From: [REDACTED]
To: [REDACTED]
Subject: RE: Deposit Our ref: 24/00037/F
Date: 22 January 2024 10:39:05
Attachments: [REDACTED]

Borough Council of
King's Lynn &
West Norfolk

GROUND FLOOR PLAN AS PROPOSED  
1/50

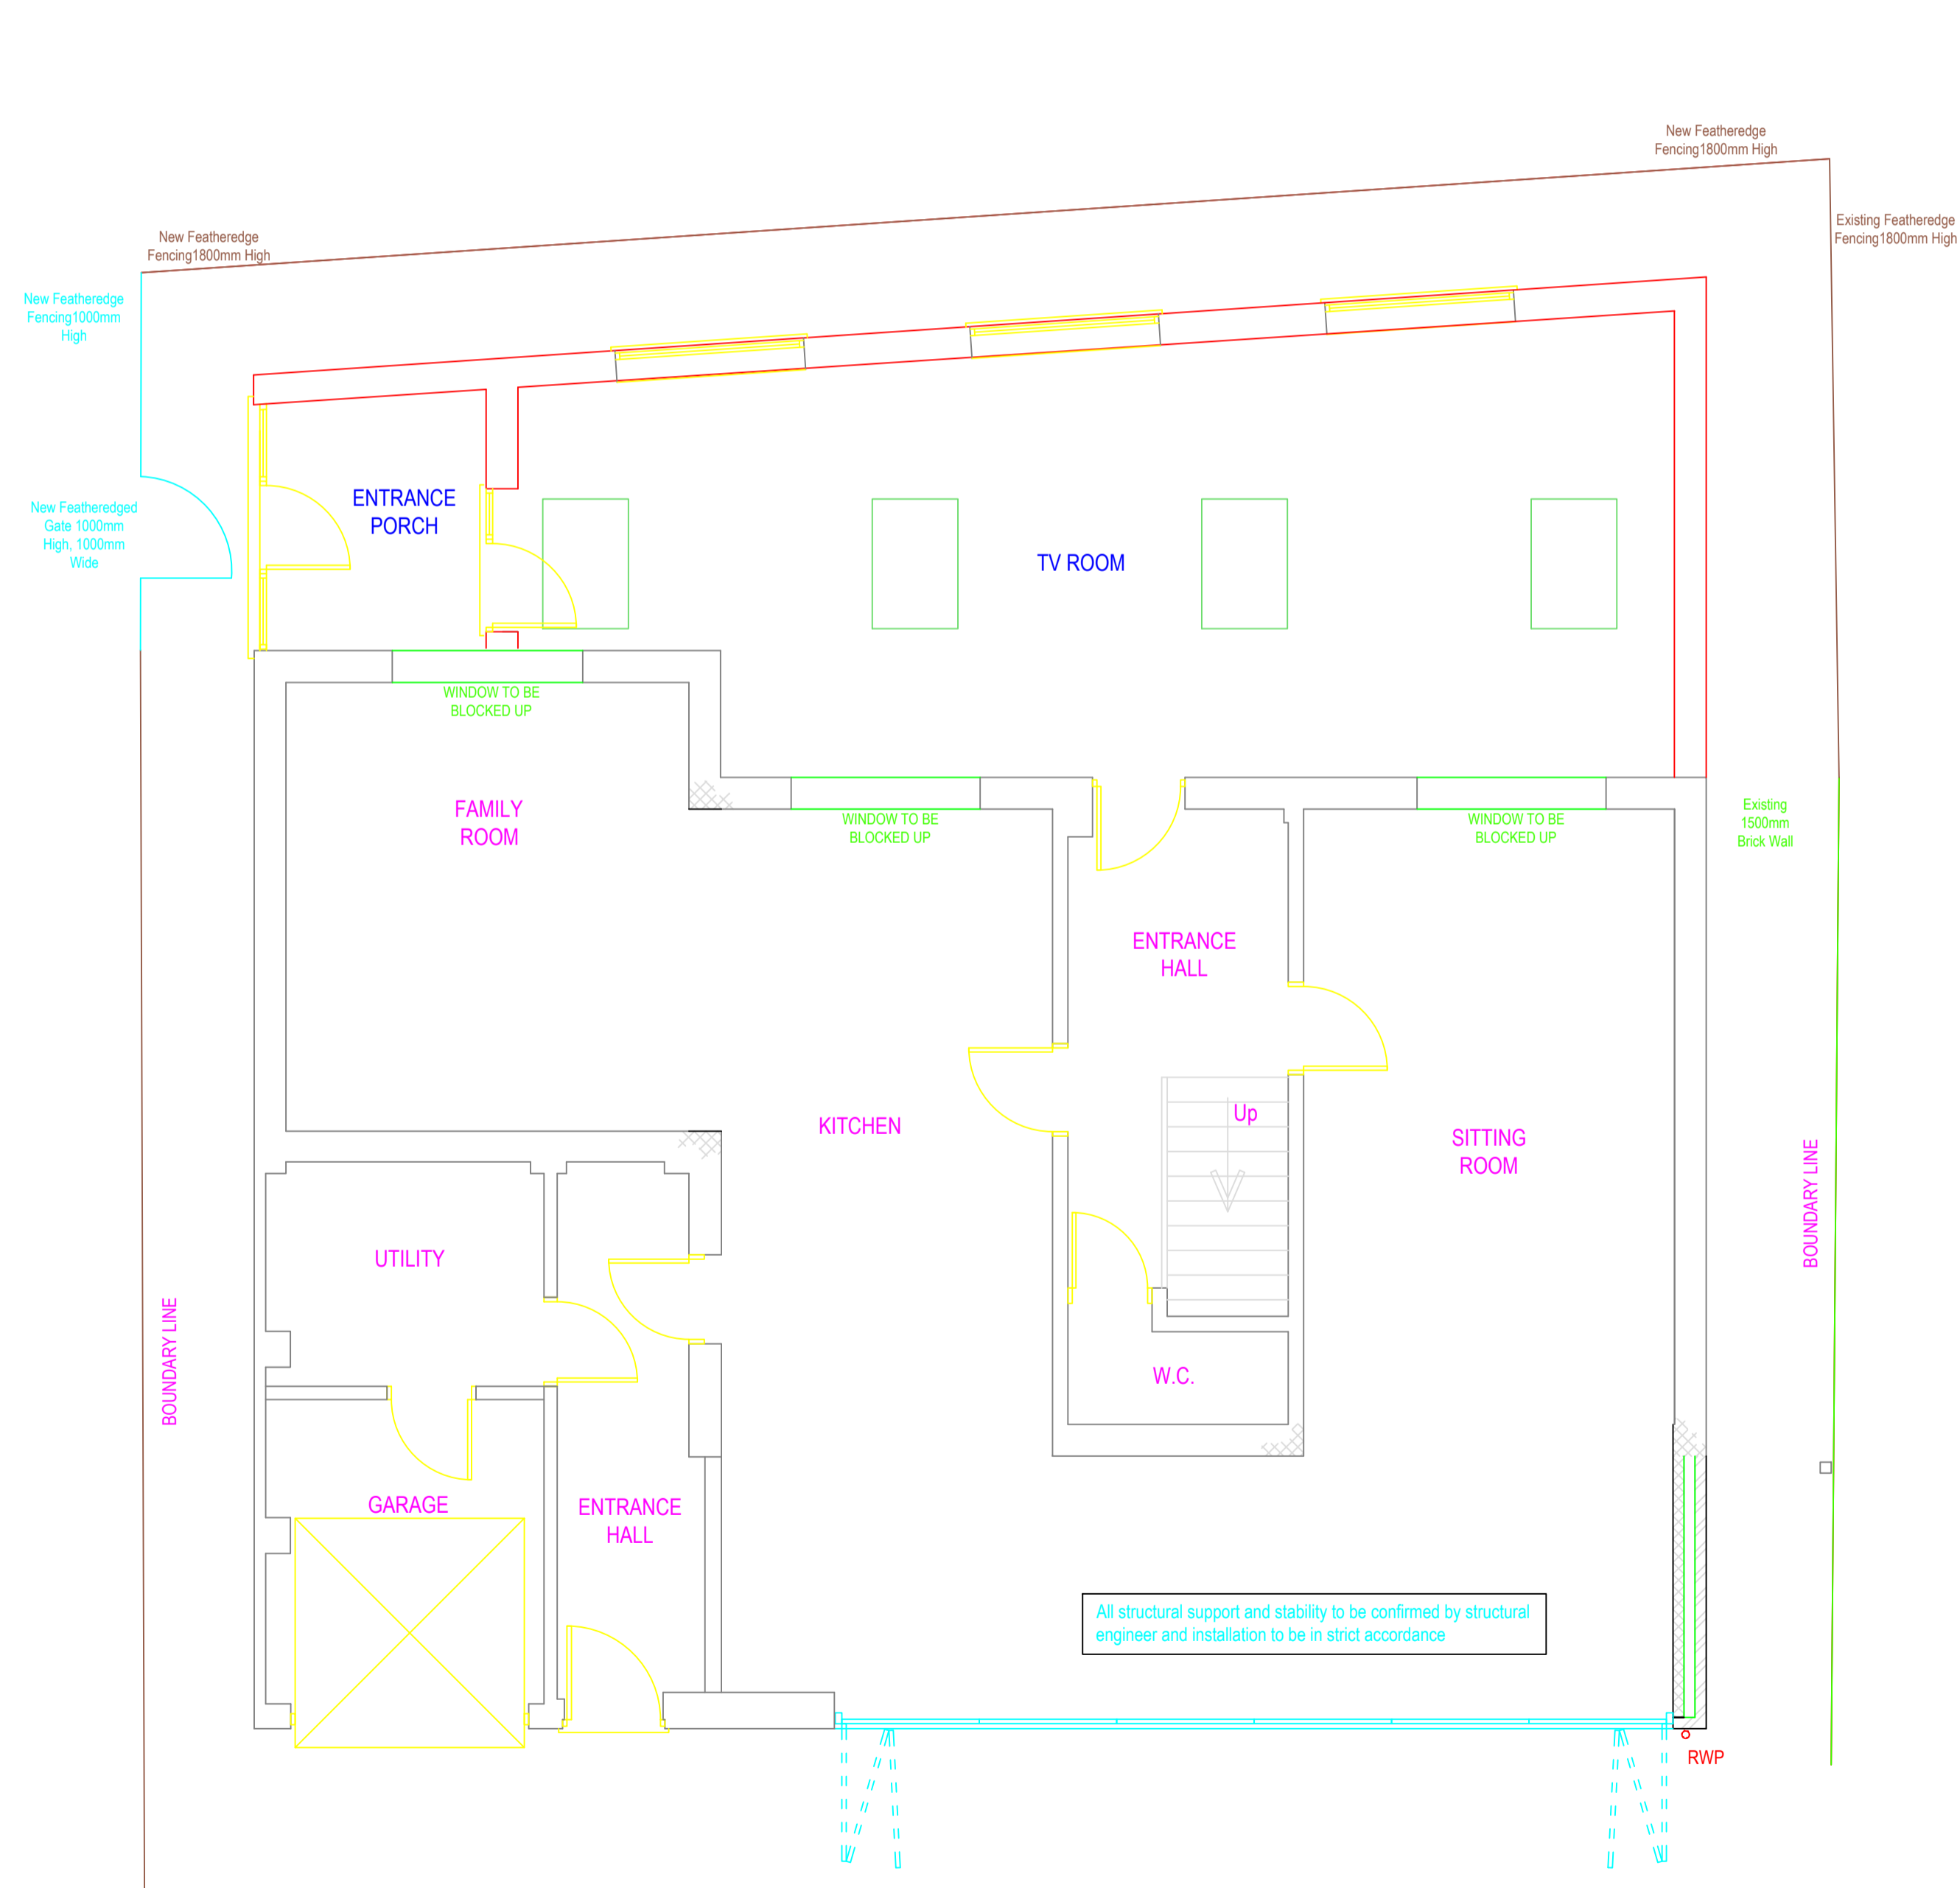
Yes, you have shown the floor levels on the drawings, I just need confirmation that the site levels are to remain as existing.

Also confirmation that the site levels will remain as existing.

Also you need to confirm that the site levels will remain as existing and that the new floor level will match the existing floor level.

The main drawings issued do show on them that all floor levels remain the same and this is shown in Red Text with a dotted line.

SITE LOCATION PLAN  
1/1250

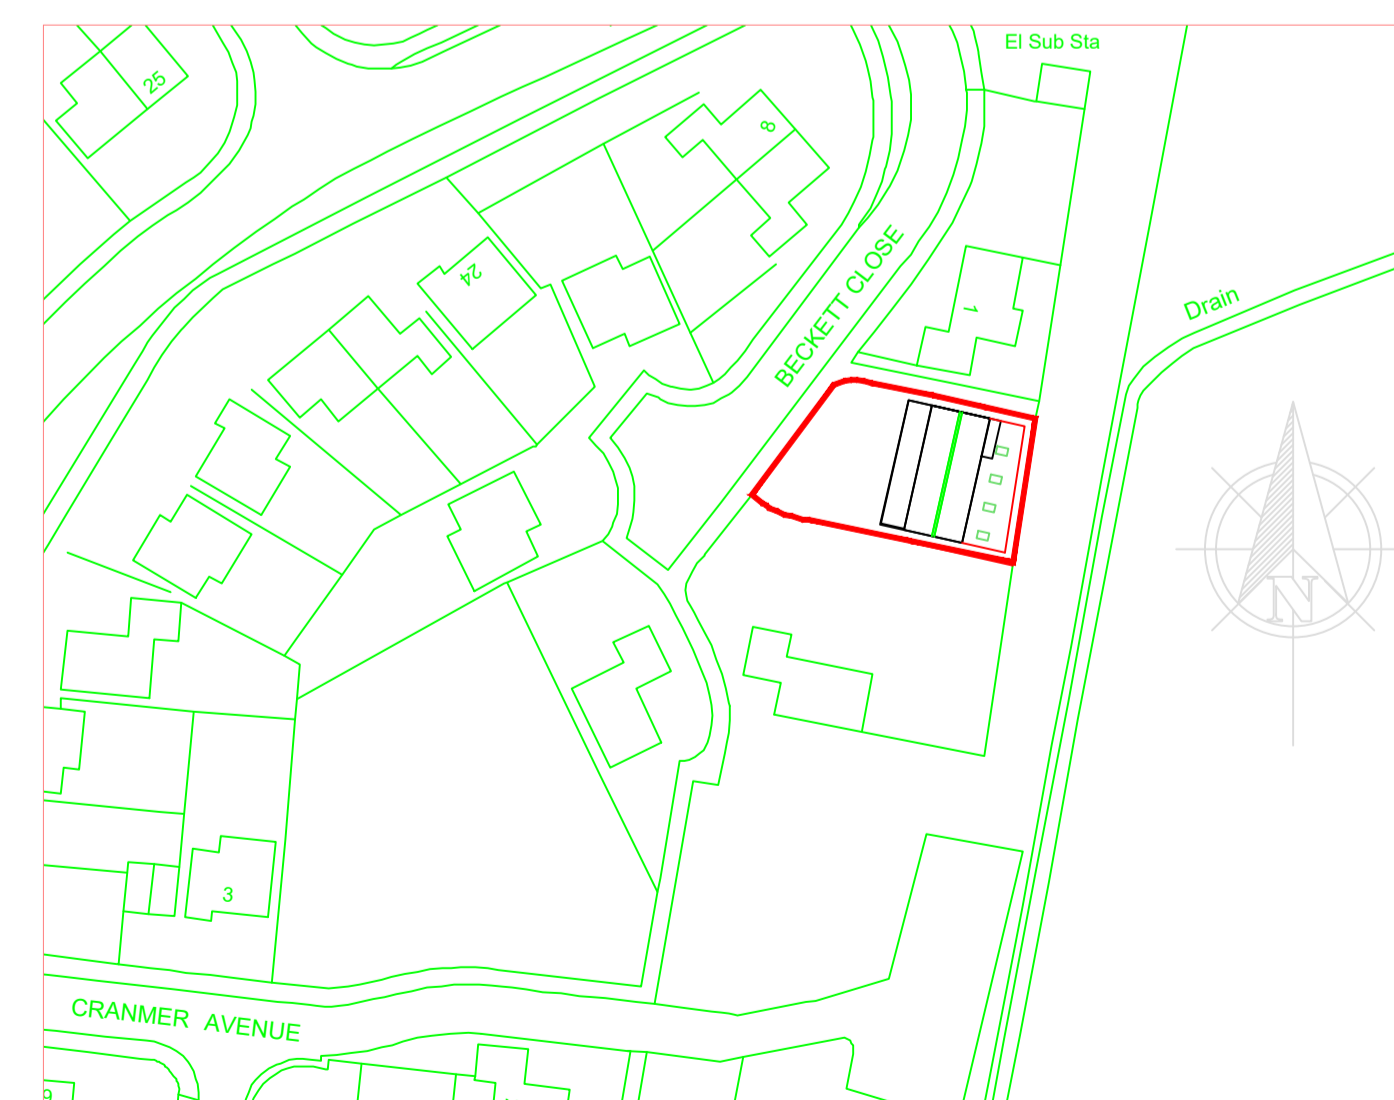
My apologies, I did forget to ask you for a block plan to a scale of 1:500 or 1:200 showing the dwelling with the extension.

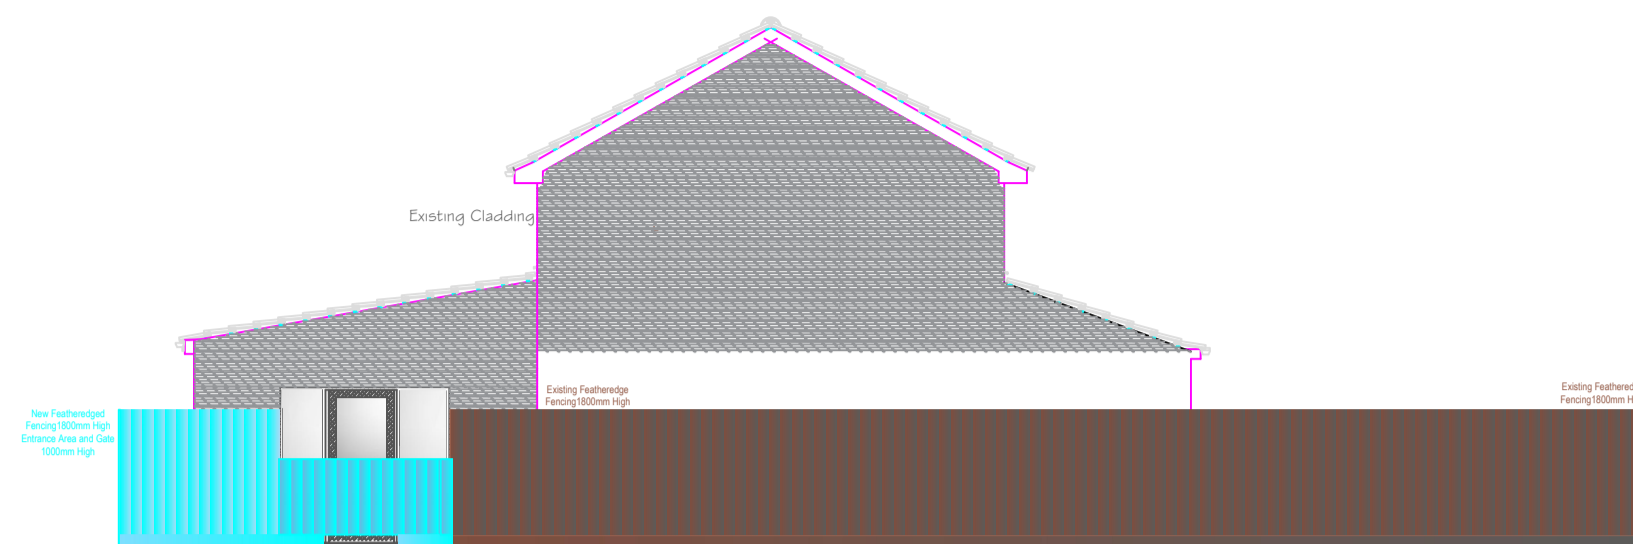
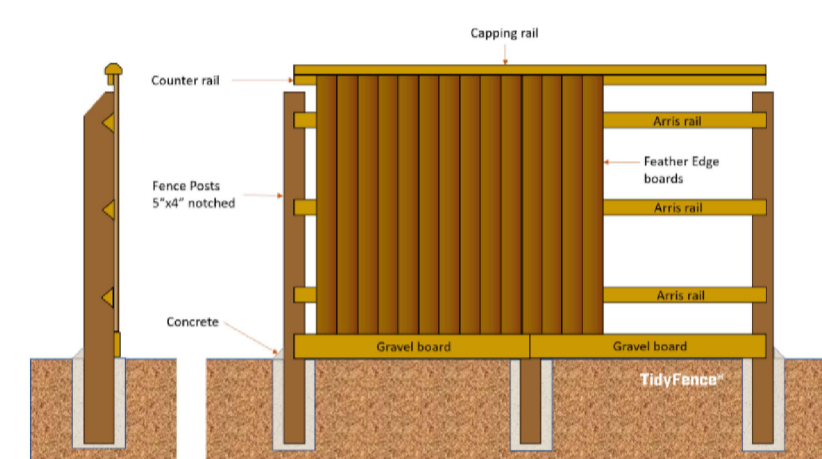
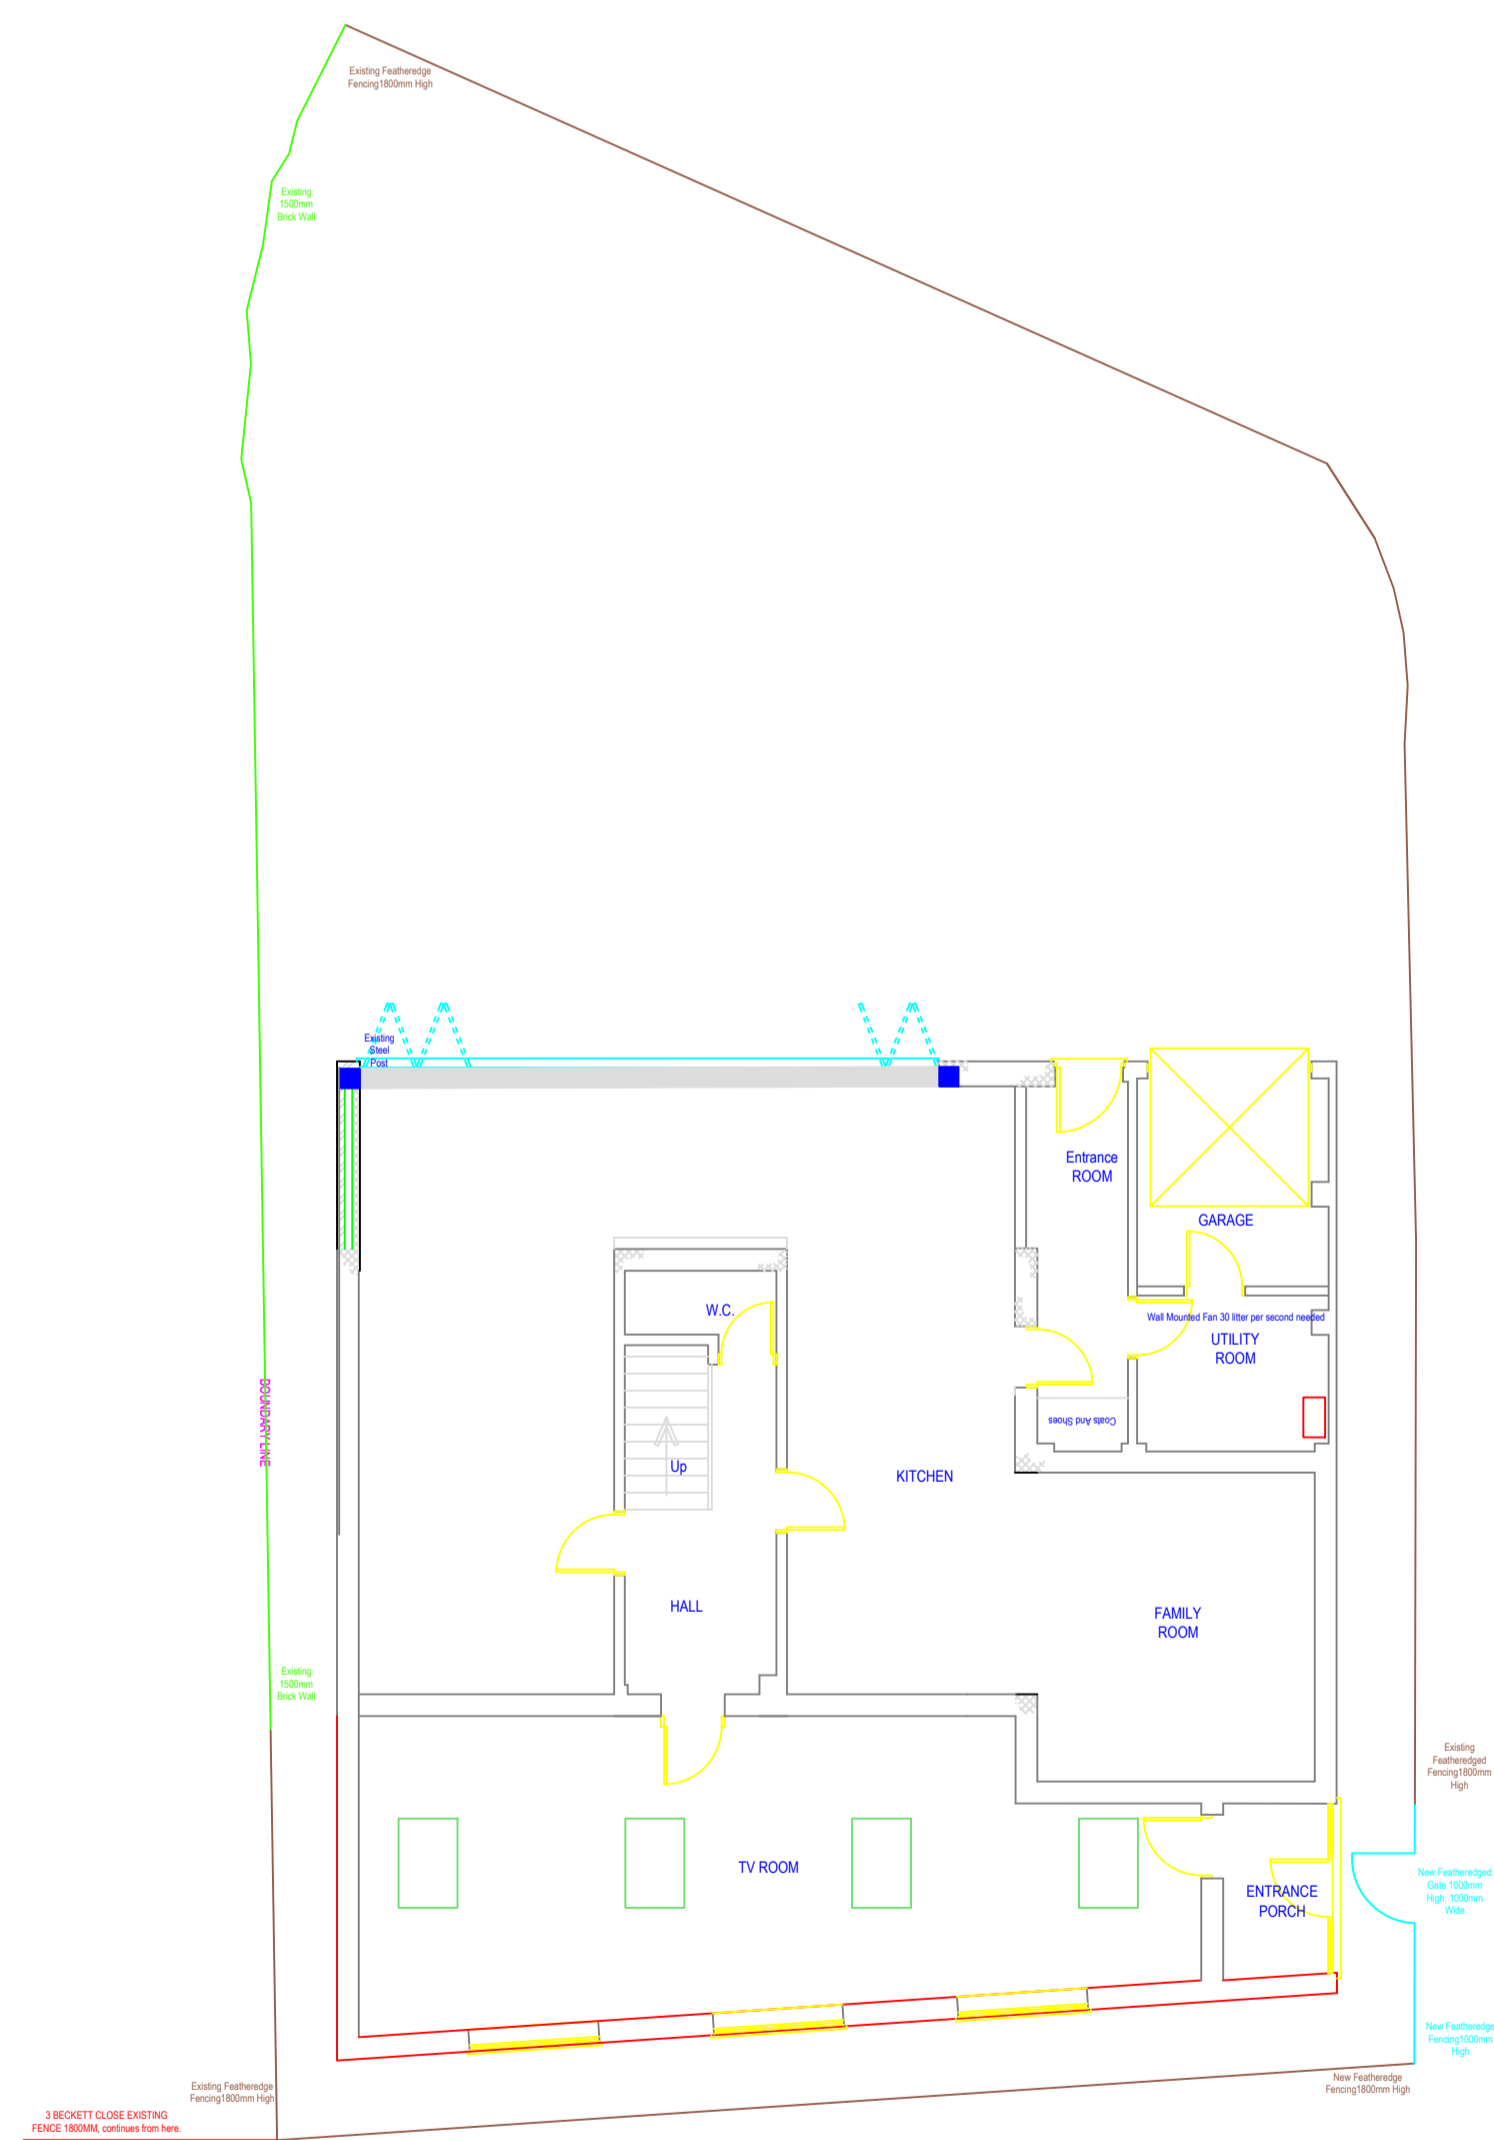
I do still require a separate scaled elevation of the fence showing the details of the fence rather than the transparent view over the front elevation.

I am missing the existing and proposed north elevation. I also need a separate elevation showing the fence details. Confirm the exact position and extent of the new fence on the proposed site plan.

Please see attached the fence drawing showing existing and proposed additions.
